GRADING & EROSION CONTROL PLAN

MONUMENT SMALL ENGINE STORAGE

PPR1946

OCTOBER 24, 2019
SHEET 1 OF 5

GRADING & EROSION CONTROL PLAN

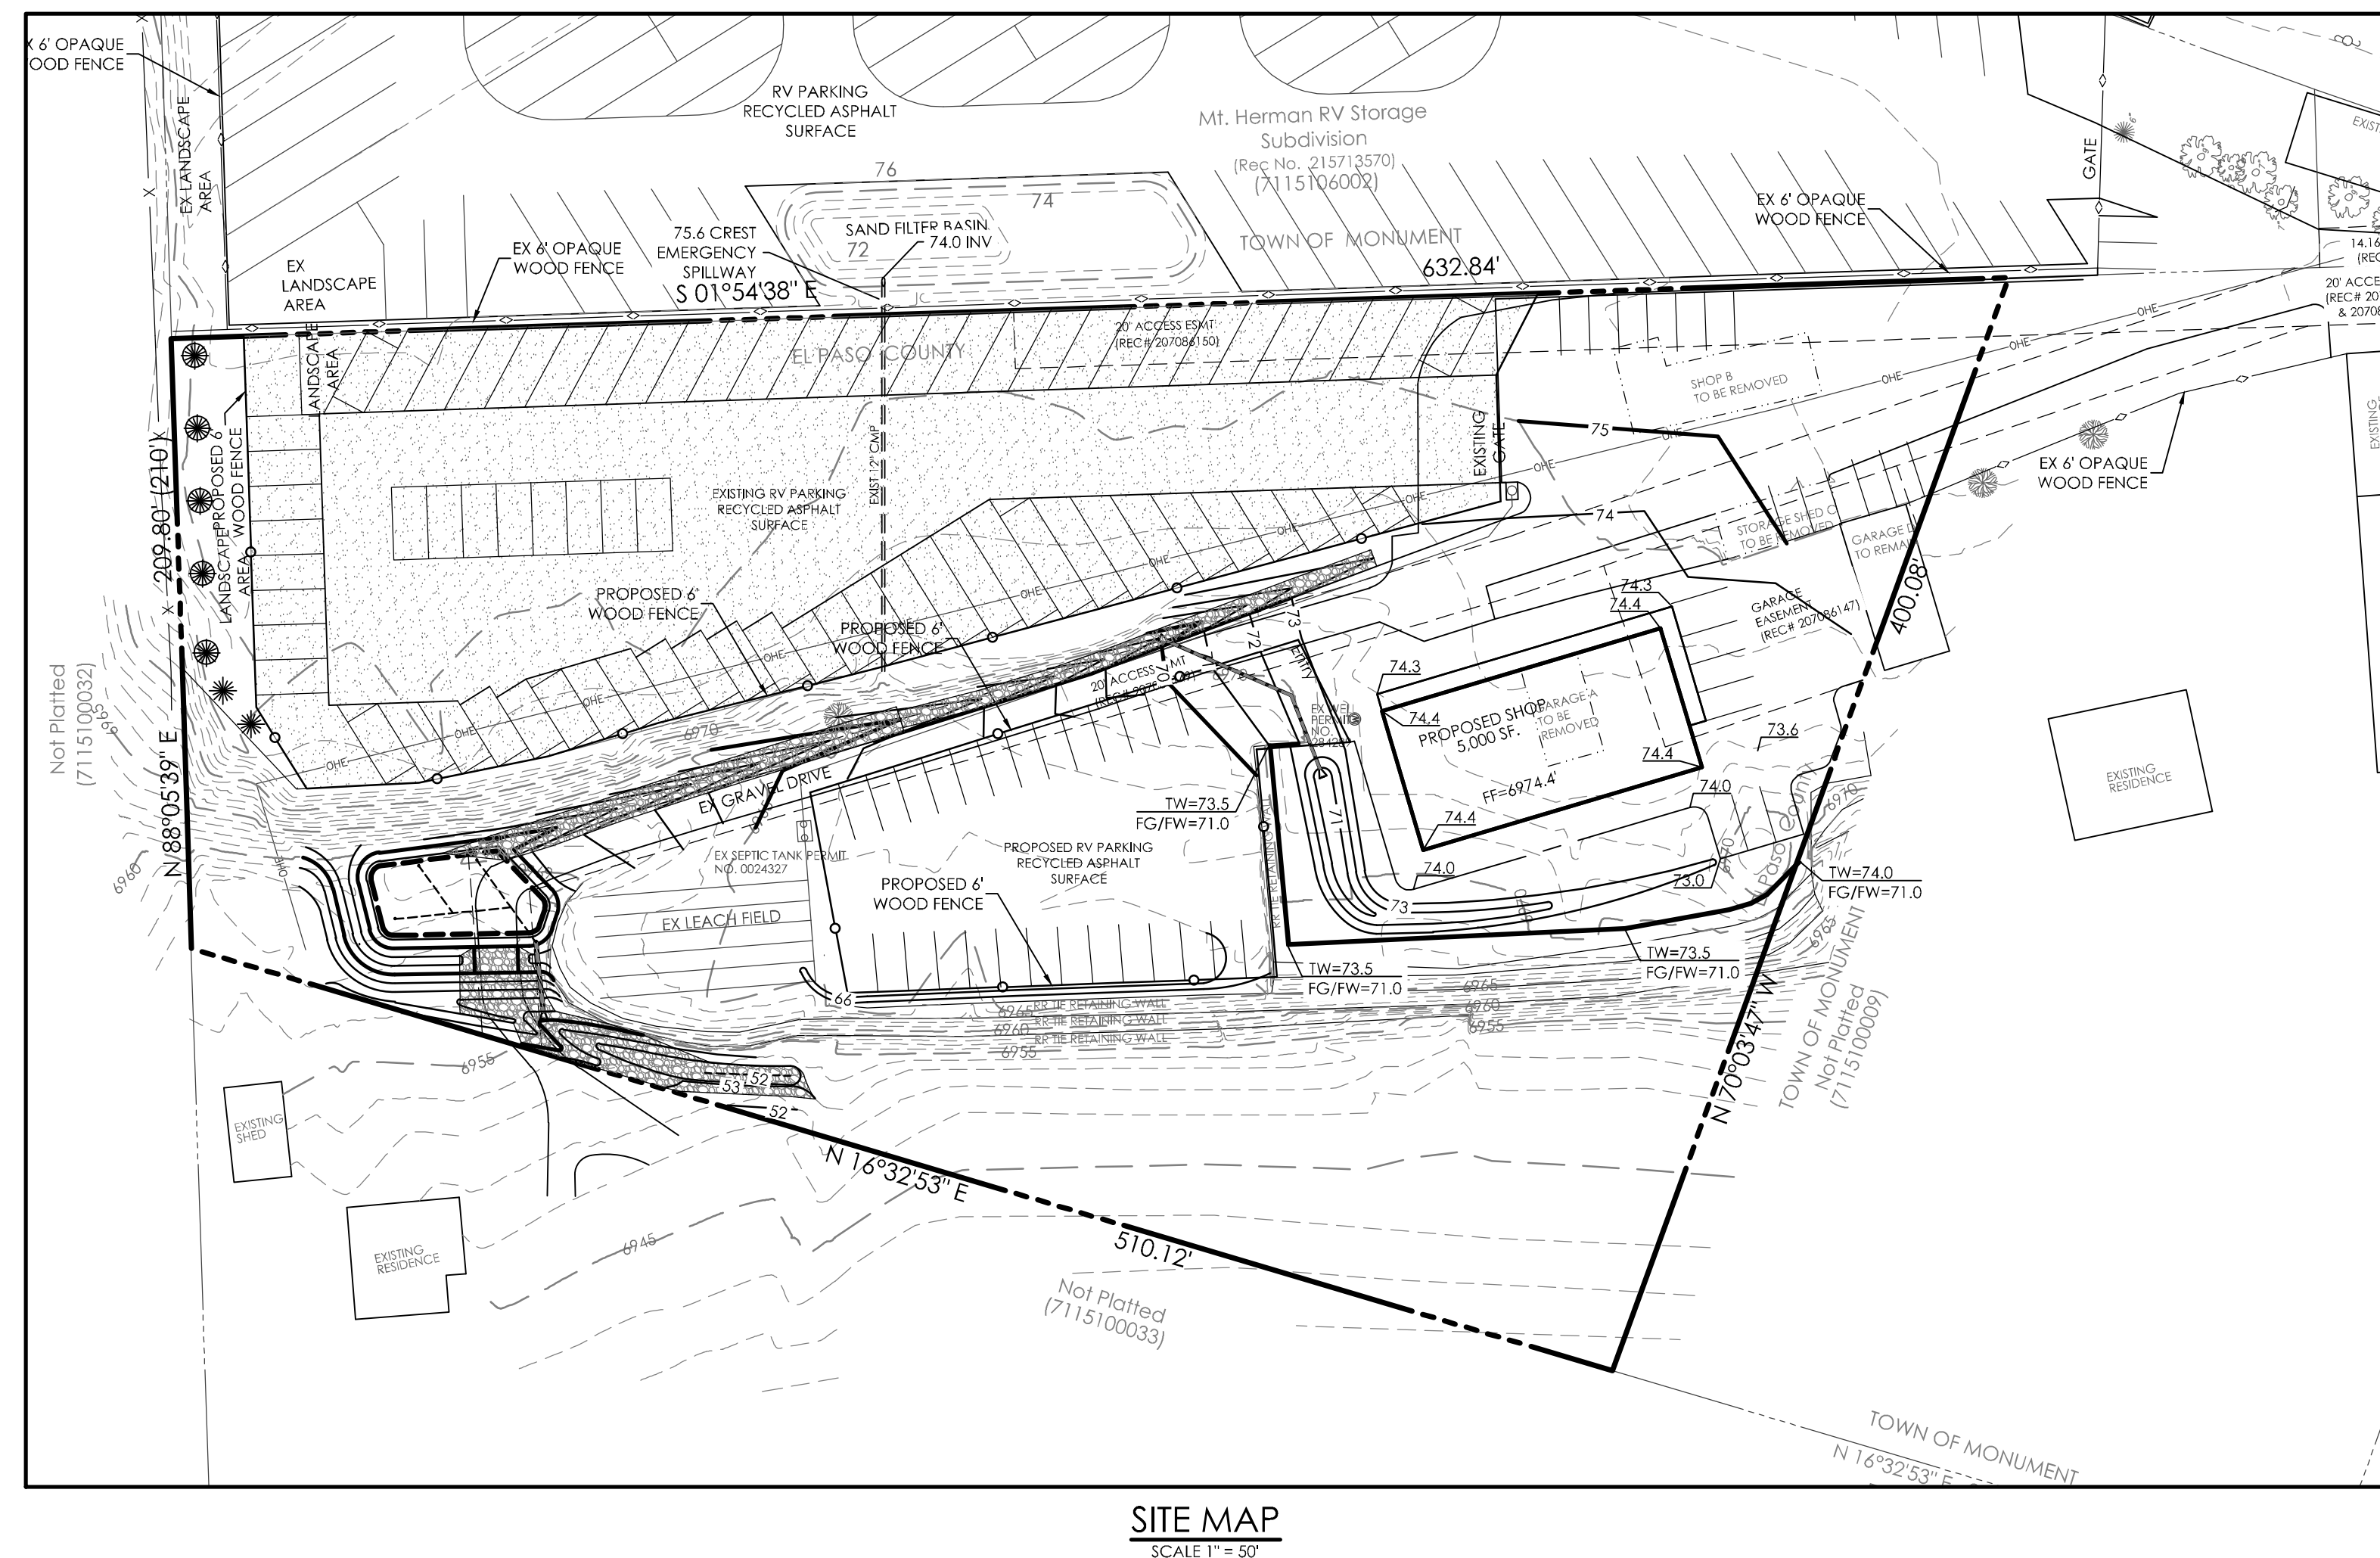
Remove items on the Revision Blocks.

GRADING PLAN

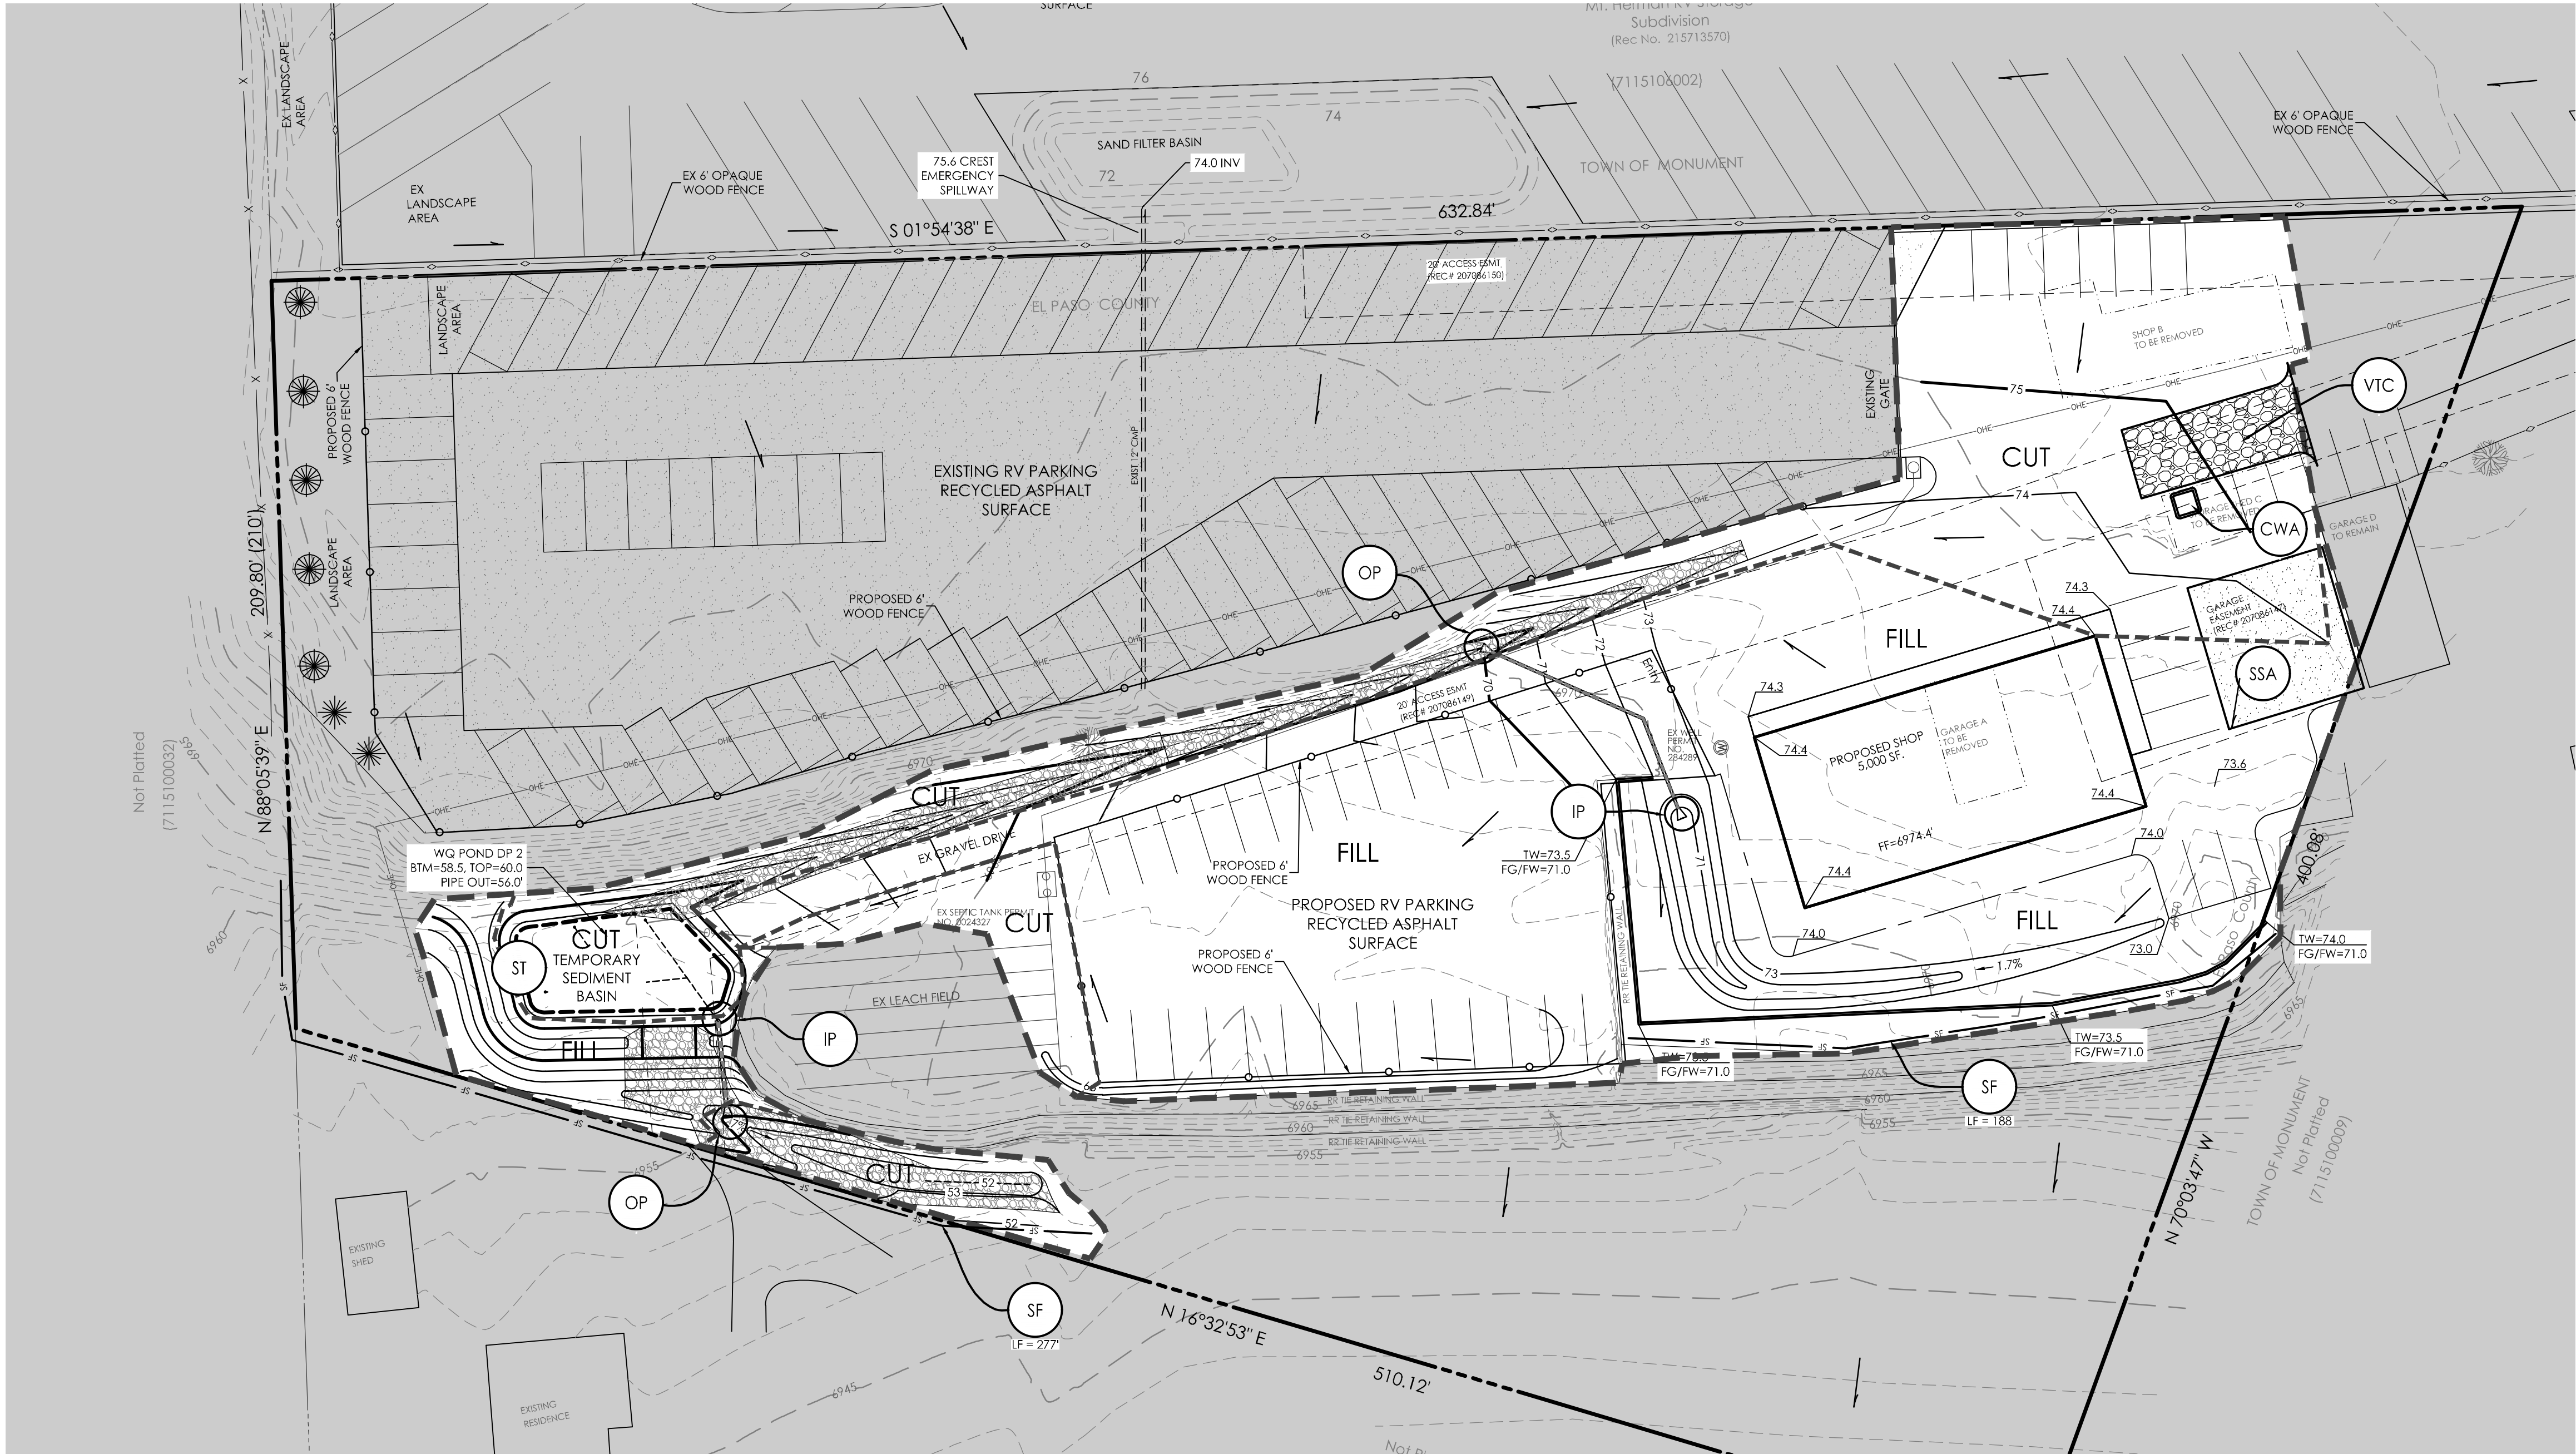
Provide hydraulic analysis of the outfall path between the spreader and the creek. Update the narrative to discuss the findings. See ECM Chapter 3 Section 3.2.4 regarding suitable outfall location definition. Contact the review engineer (Gilbert LaForce, 719-520-7945) if you need clarification.
